Recommendation Report for Planning Permission for Works or Extension to a Dwelling

REF NO: FP/197/20/HH

LOCATION: 15 Blakes Road
Felpham
PO22 7EE

PROPOSAL: Two storey extension to front elevation, extension over rear terrace, single storey side and rear extension and loft conversion with rear dormer window and two front facing dormer windows. Rear facing roof terrace. Alterations to the vehicular access

Drawing No.	Date:
C.1063 - 08	20-09-20
Rev.	Date:
H.D	30-11-20

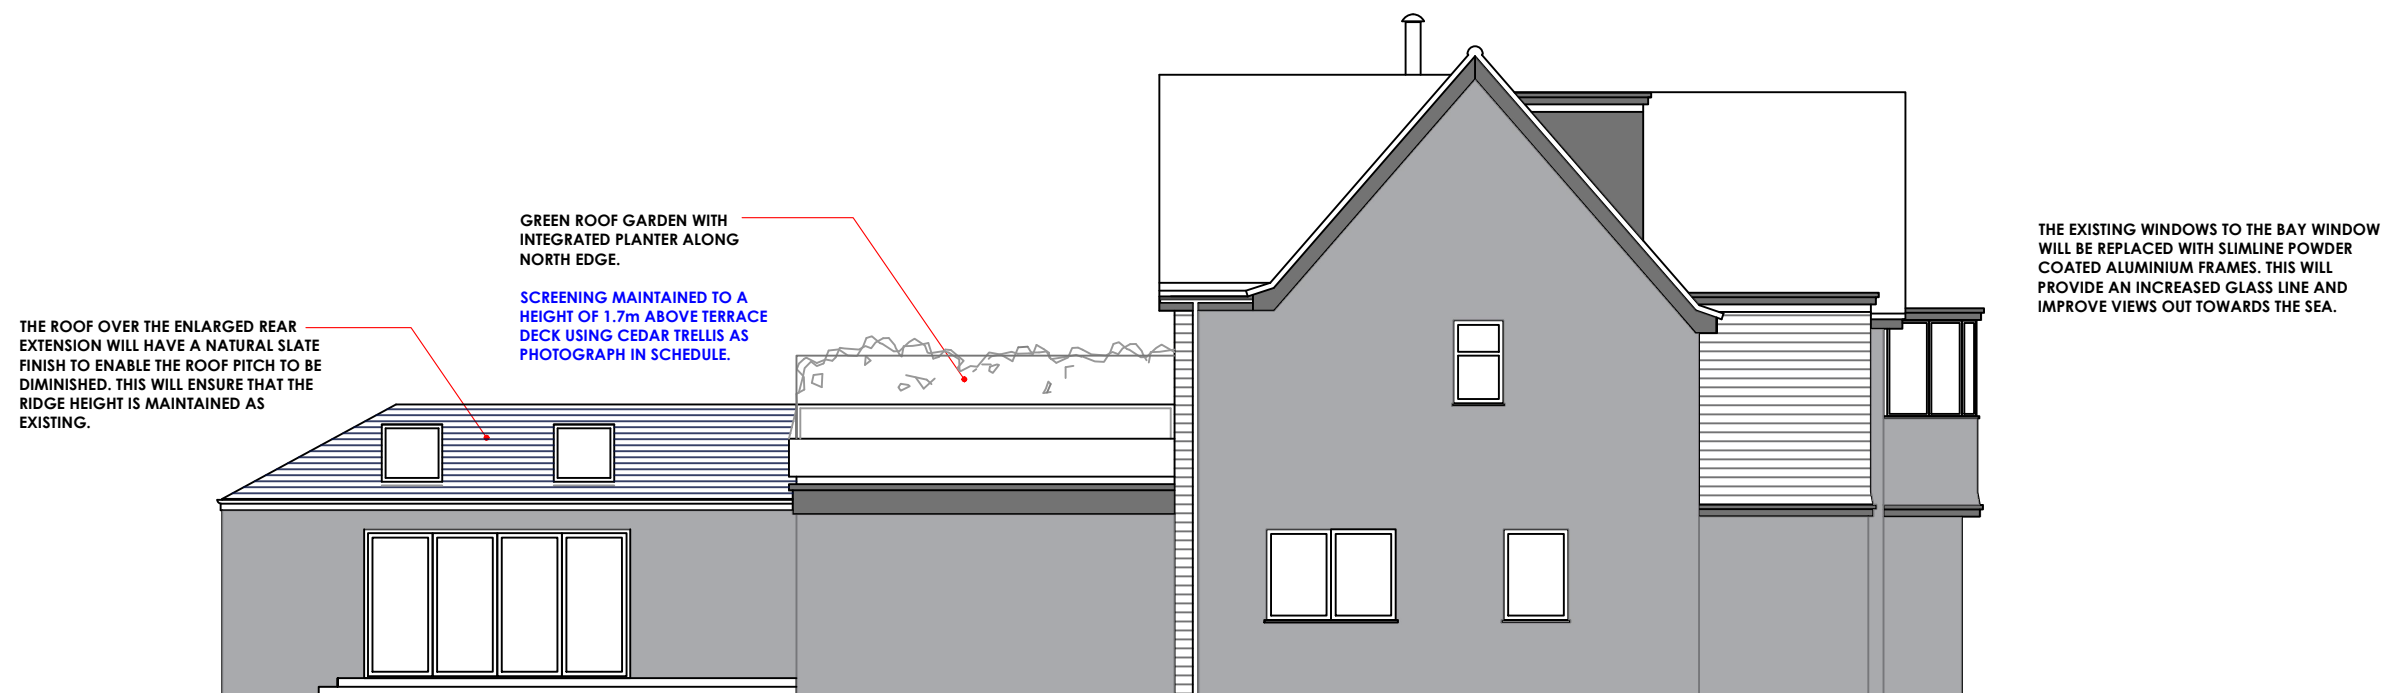
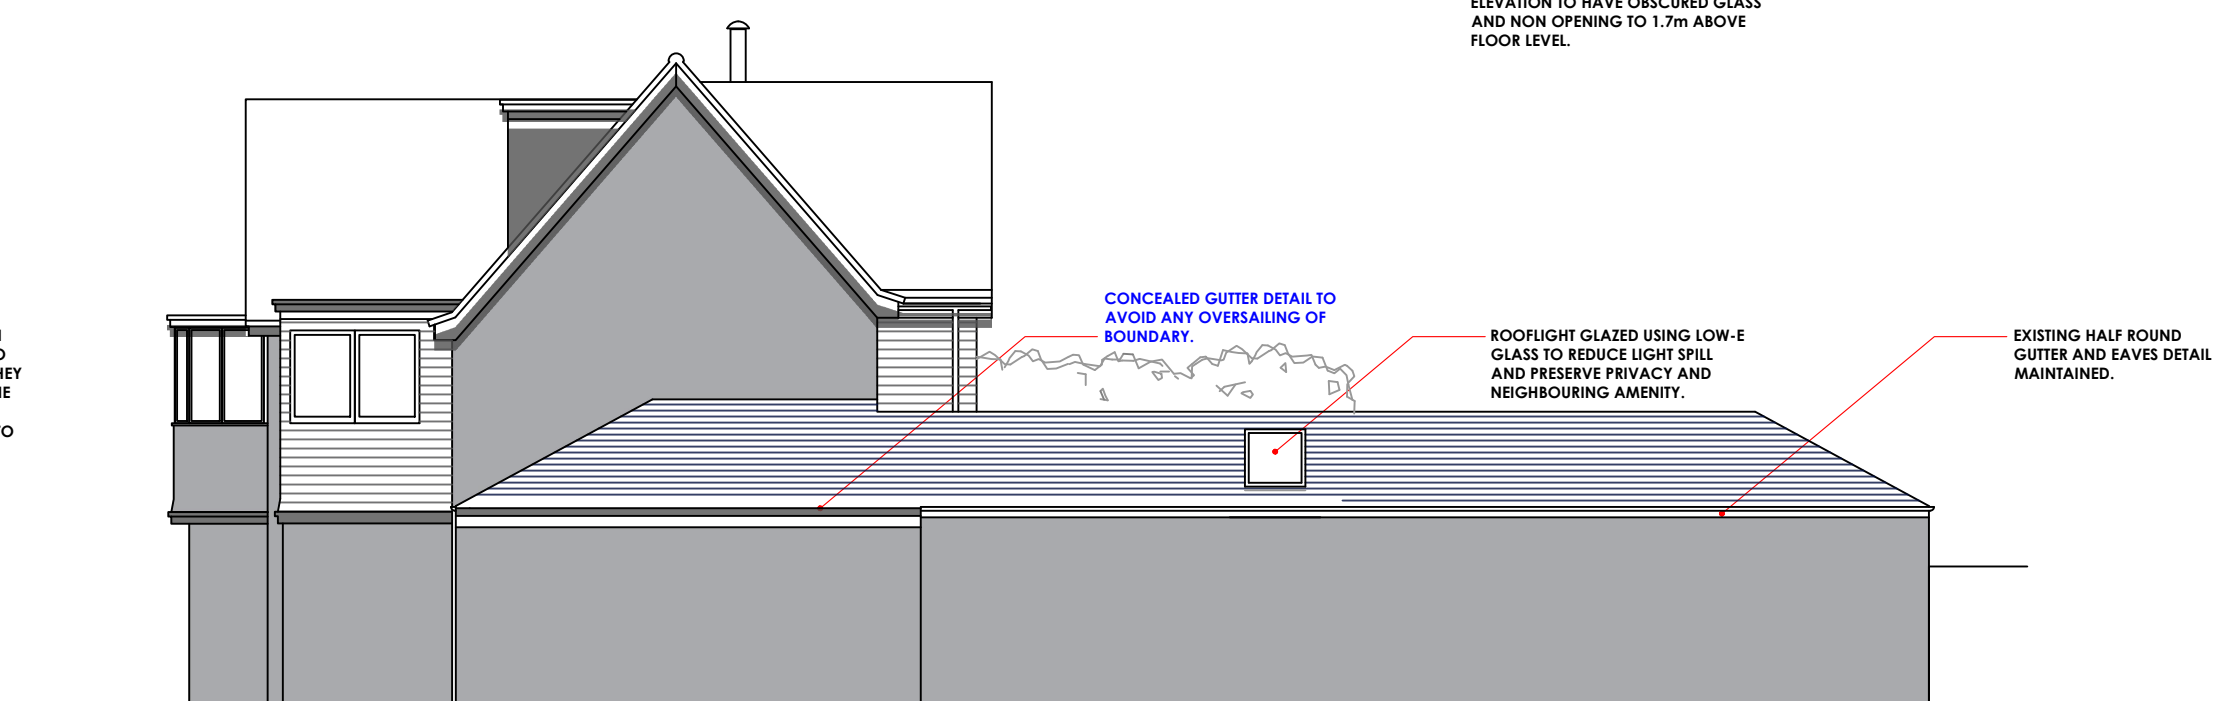
The balcony proposes a cedar panel screen to the north elevation which sits behind a planting wall. This will have a height of 1.7m and is considered sufficient to ensure the balcony will not give rise to unacceptable overlooking upon this elevation.

The fenestration to the first floor will alter however it is not considered to give rise to views additional to that which are already achievable. There will be an additional first floor window to the northern elevation which would overlook the neighbouring property. This will serve a bathroom and will be conditioned to remain obscured glazed. There will also be 2 ground floor windows to the main dwelling however with fencing and hedging in place are not deemed to result in adverse views.

- 3 The first floor window on the northern elevation of the building shall at all times be glazed with obscured glass and only openable at a high level, at least 1.7m above finished floor level.

- 4 The balcony screening shall be constructed to the northern and eastern side of the balcony to a height of 1.7m as shown on the approved plan C.1063 - 07 and C.1063 - 08 . It shall be installed prior to the first use of the balcony and be retained thereafter in perpetuity.

Drawing No.	Date:
C.1063 - 05	20-09-20
Rev.	Date:
H.F	09-12-20

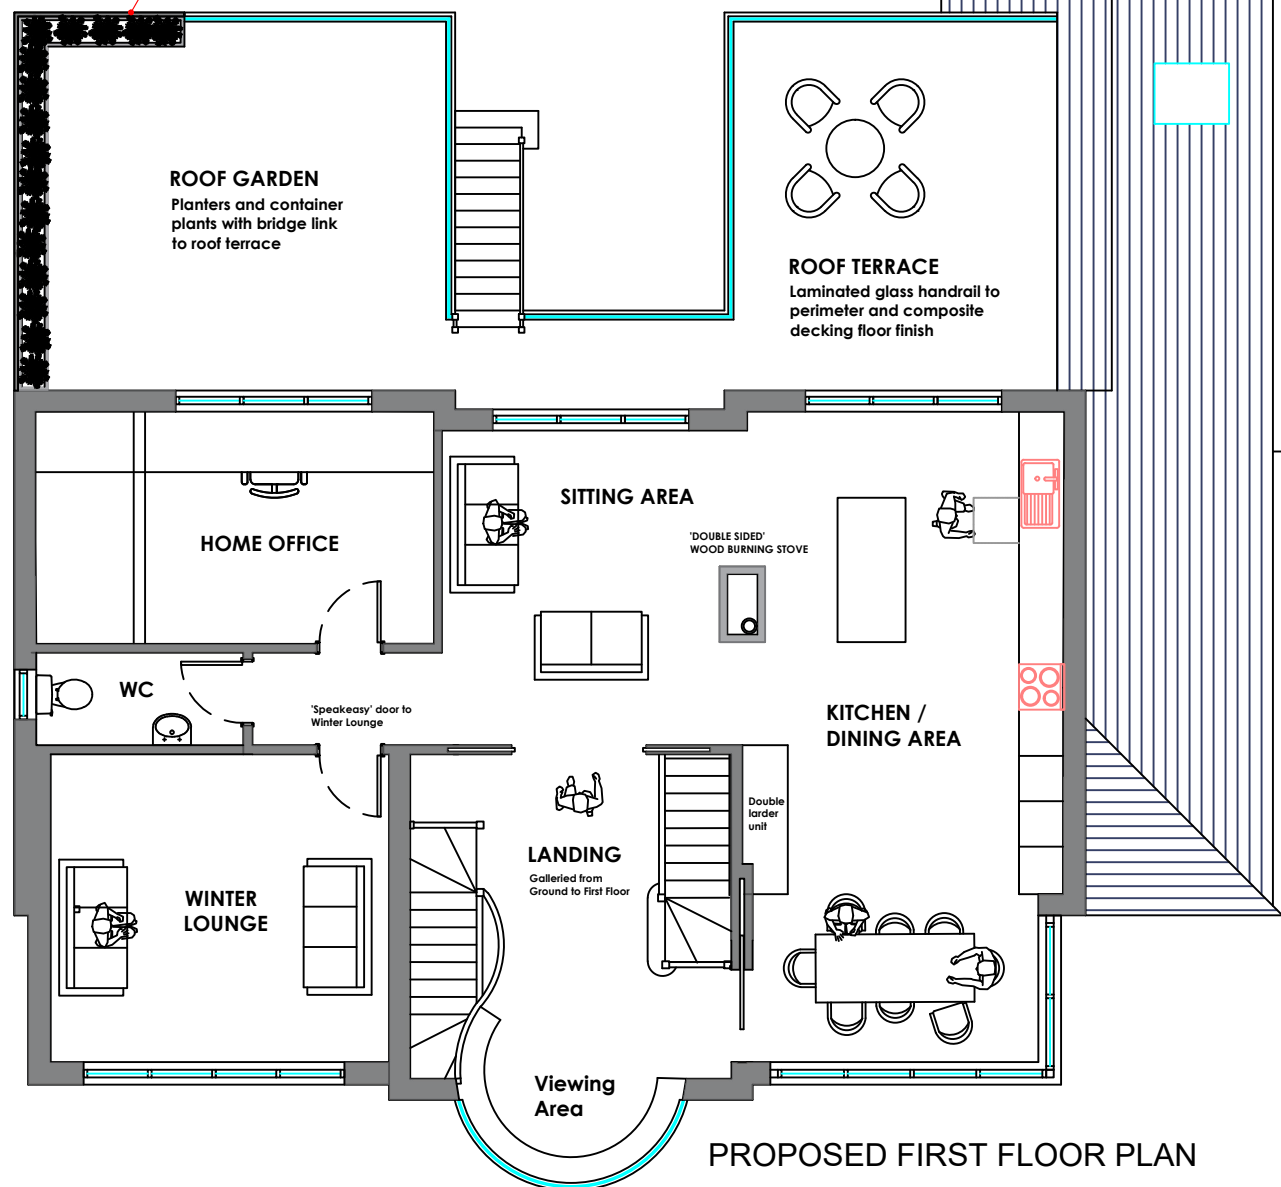
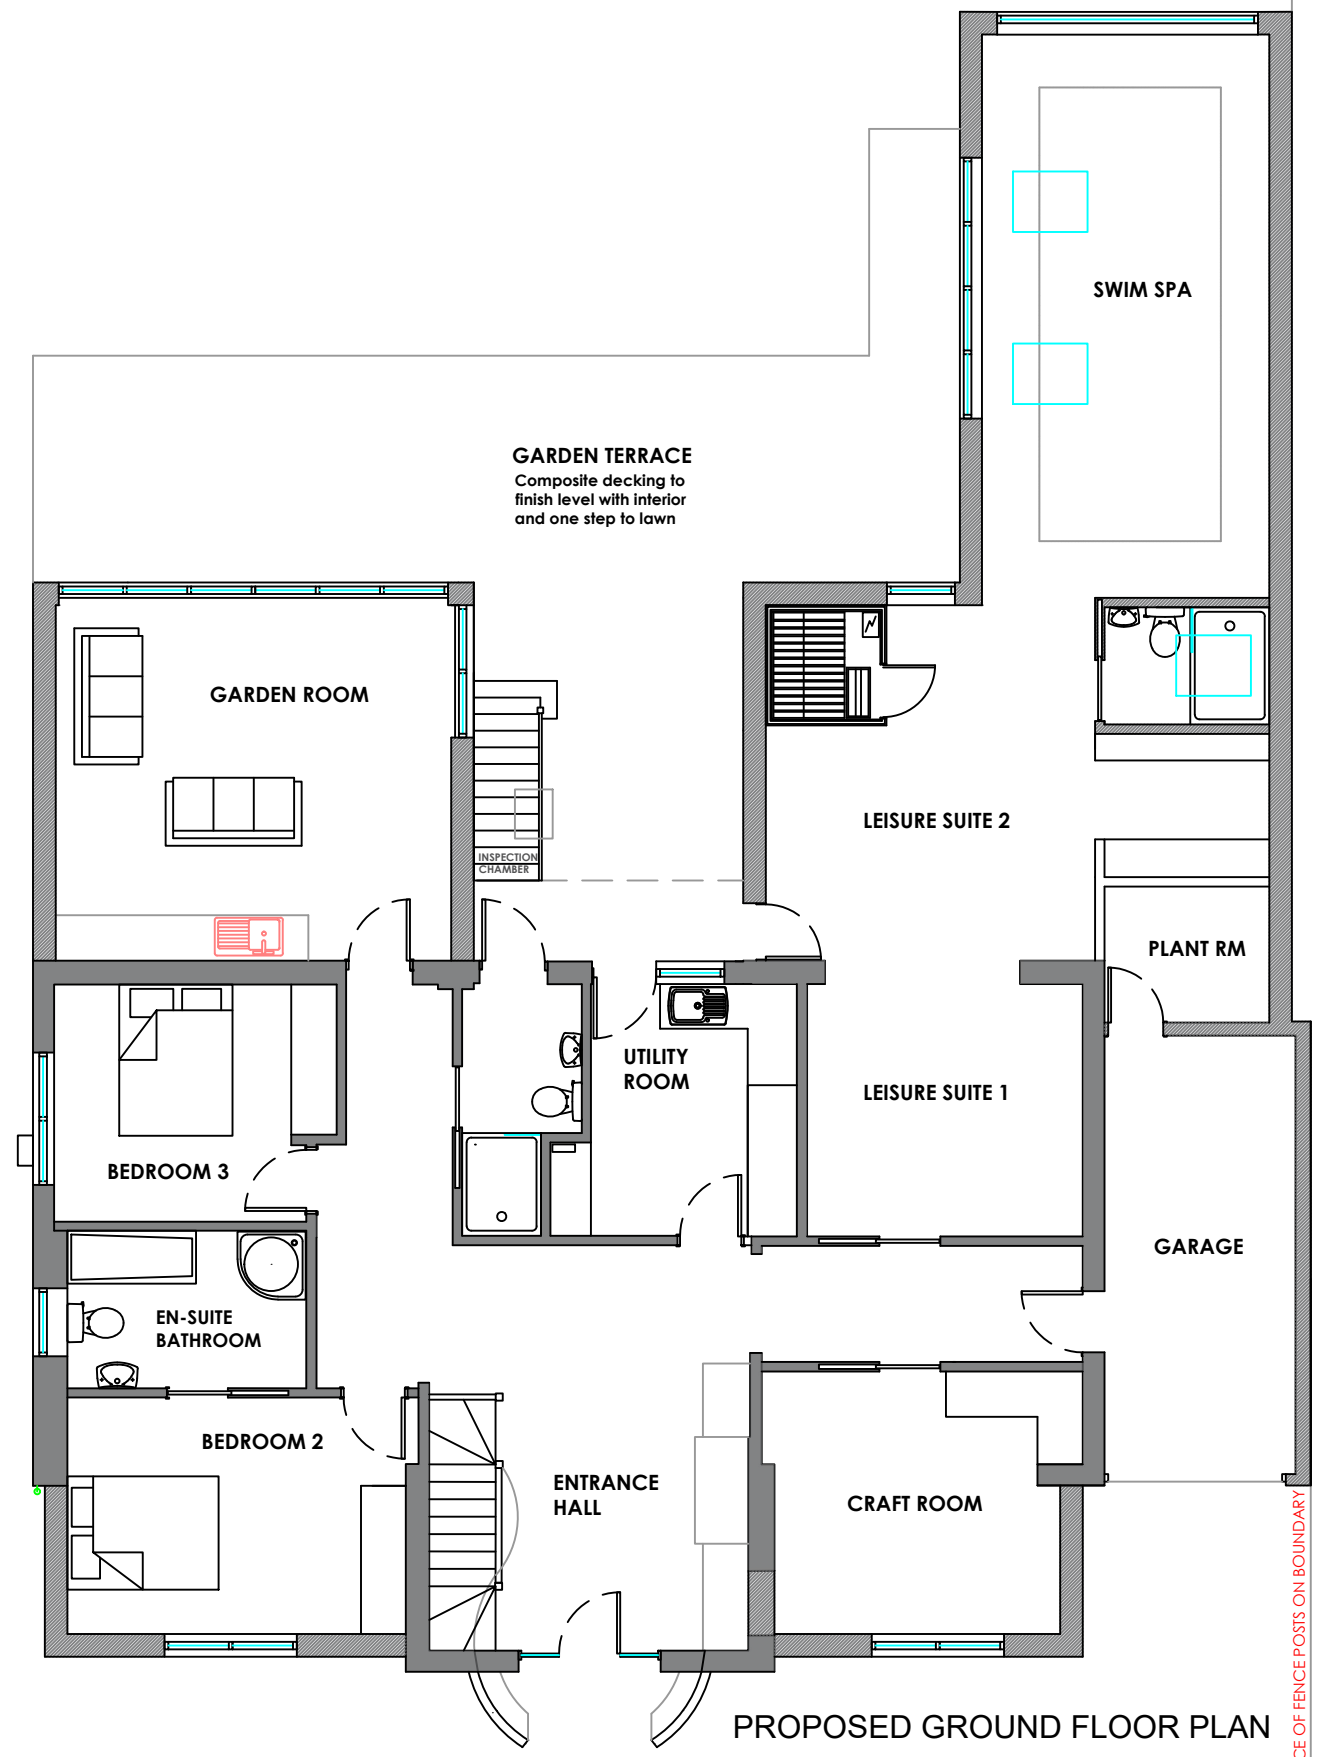
The rear elevation to No.4 Culver Road has a number of windows facing the garden of the host dwelling and the balcony would provide some overlooking, additional to that which is currently achievable. As a result the balcony screening will extend along the eastern side of the balcony for 2.2m. This will provide a minimum of 6.8m to the boundary of No.4 when looking at a 45 degree angle. As such the screening is considered to mitigate against the most significant overlooking impact and is now acceptable given the typical level of balcony use.
